Bristol City Council Development Management

Delegated Report and Decision

Application No: 20/06253/H **Registered:** 23 December 2020

Raise the height of the existing detached garage, and convert to habitable space (Granny Annexe).

Postcode: BS5 7PR	Drawing Title: Garage Elevations
Date: Nov 2020	Drawing No: 170/HR/SG/G/04/P
Drawn: D.H	Option: -
Rev: A

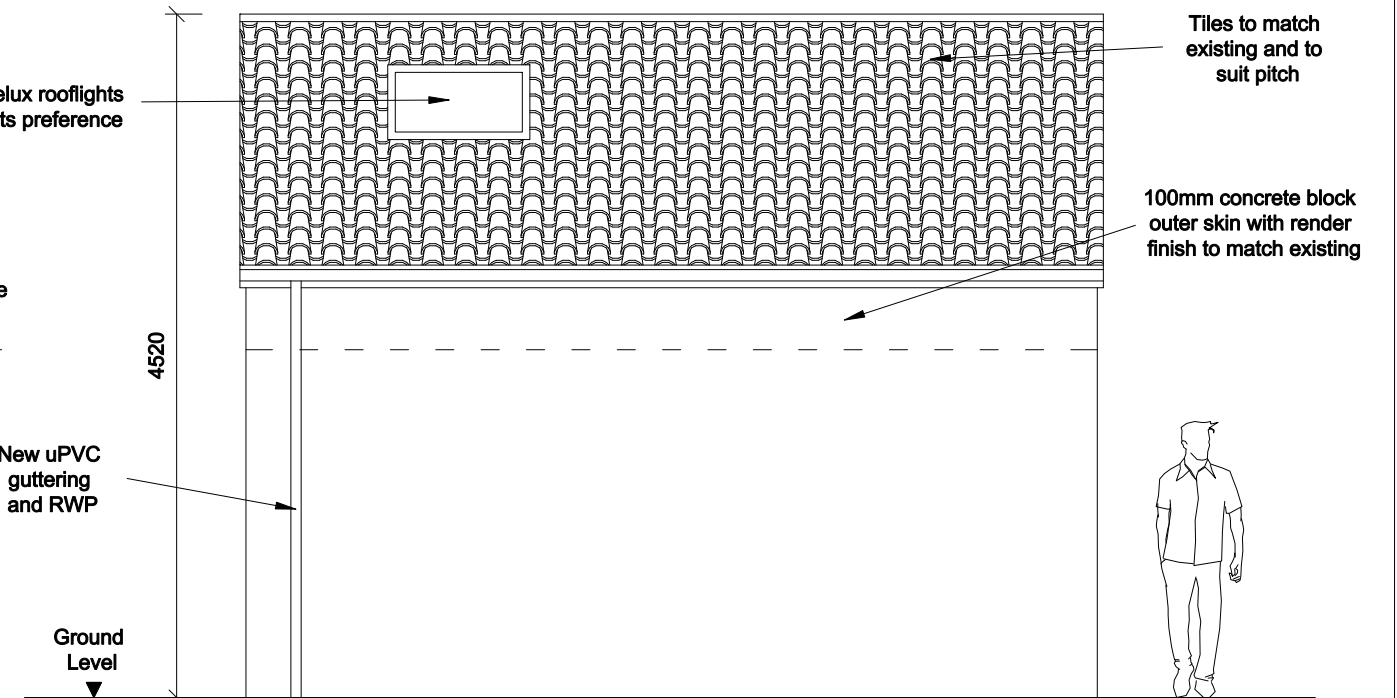
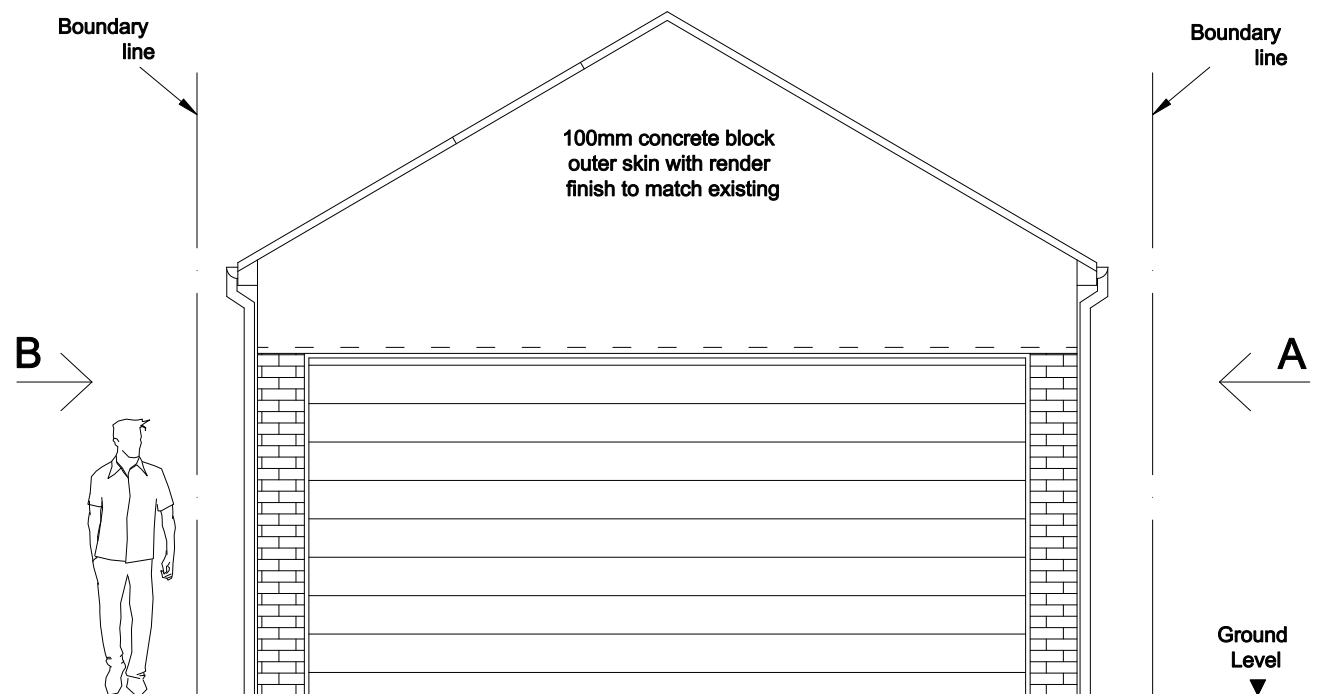
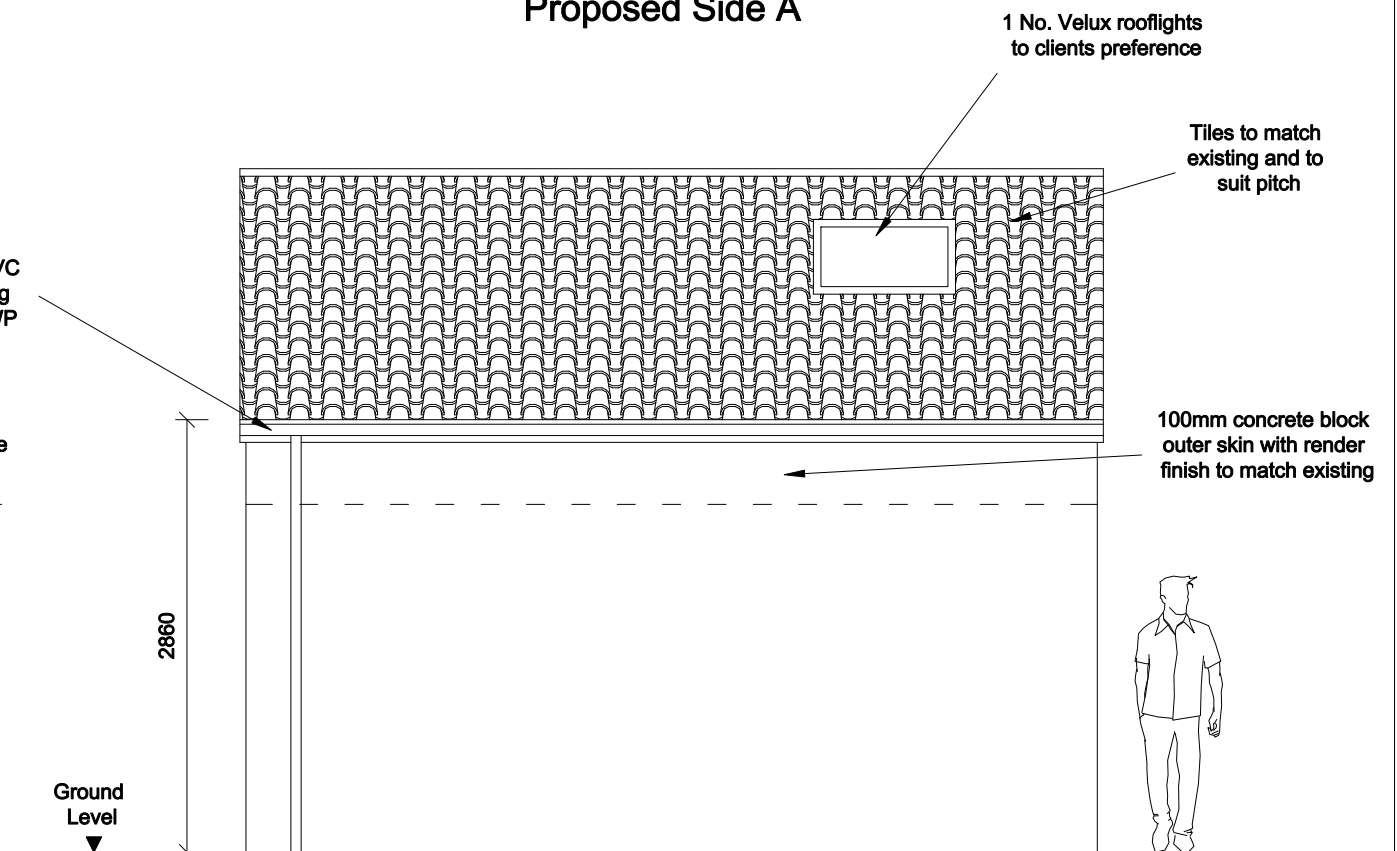
The proposal has been revised during the lifetime of this application, to reduce the height of the eaves and ridge, incorporating a steeper roof pitch and removing the timber cladding. The amendments have been made in response to concerns reading the impact of the proposal on the character of the

The design of the proposed development would retain a single storey character to the building and therefore is considered to reflect the character of the property and the surrounding area.

The scale of the proposed development maintains visual subservience to the host dwelling and retains the single storey character of the building.
